From: Hanson, Guy on behalf of DM Conservation and Architecture
Sent: 15 November 2023 10:32
To: Potter, Elizabeth
Cc: planning.comments@york.gov.uk
Subject: RE: Planning Application Consultation 23/01940/FUL at Town Farmhouse 25 Church Lane

Town Farmhouse
25 Church Lane
Nether Poppleton
York

25 Church Lane ~ YO26 6LF	
Title:-	Elevations as Proposed
Scale:-	1:100@A3
Date:-	10-23
Drg N°:-	B/111-204E

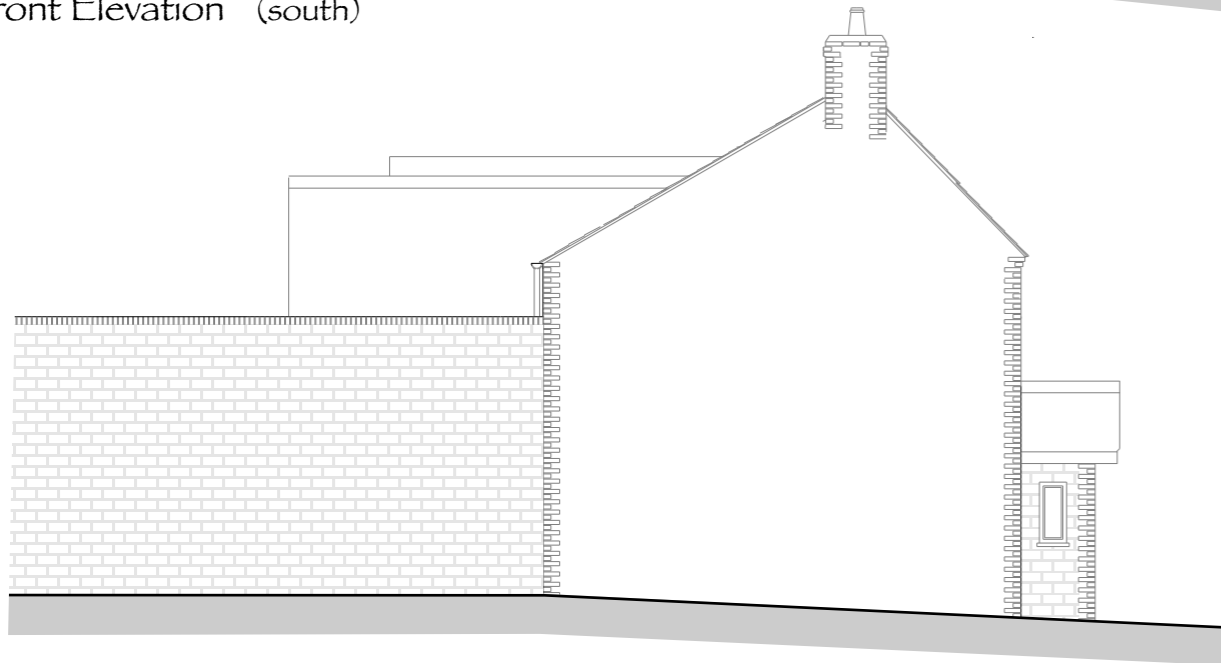
- I anticipated during enforcement that this raising of the ridge would also raise the eaves which would be a further concern. This has been largely avoided by pushing the ridge point asymmetrical to the back of the chimney (which is odd and not supported in itself) but there does appear to be some minor raising of the eaves. This should be clarified.

- The contractor emailed me yesterday about approving additional bricks. I don't think this is part of this application?
- There are some other minor alterations to the rear compared to the previously approved scheme (lantern added to the extension; minor window alterations; chimney removal). They are not assessed here in detail as they are not the substantive issue, beyond: lantern ok, windows should be more like the host building with further sub division; chimney is likely part of the collapsed fenestration(?) and there is little purpose in rebuilding it.

Drg N°:-
B/111-205D

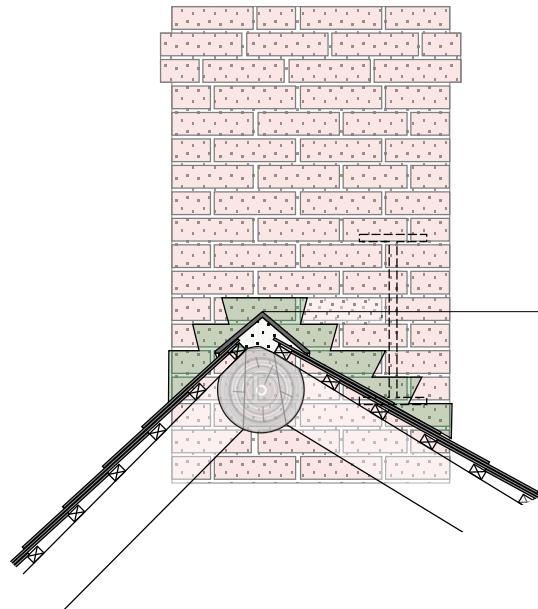
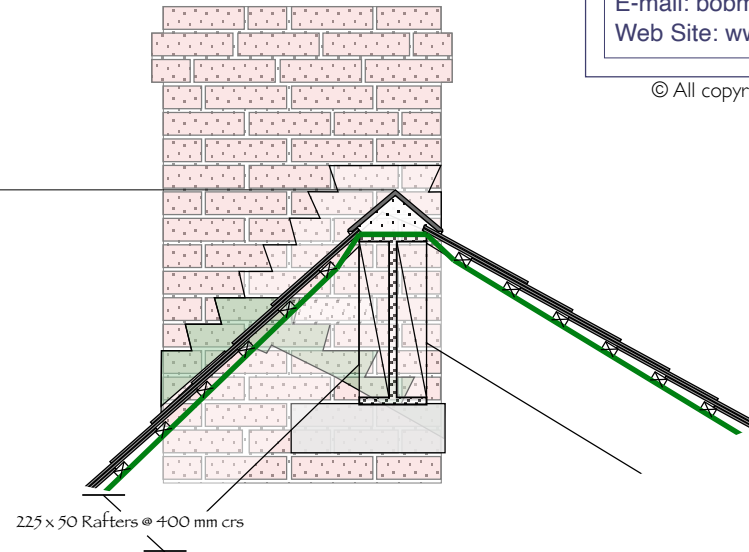
- Drawing B/111-205D has been produce to quantify the proposed roof raising as 0.322m. My initial assessment was that the raised roof would be approx. 0.5m. The current unapproved beam appears to be accurately located in the drawing but I doubt the ridge tile will be constructed as drawn. It is usual for a ridge tile to bed itself on top of the tiles, and allowing for further construction tolerances it will be higher than this. If we wait and see and I'm right it will be very difficult to enforce again if we accept this.
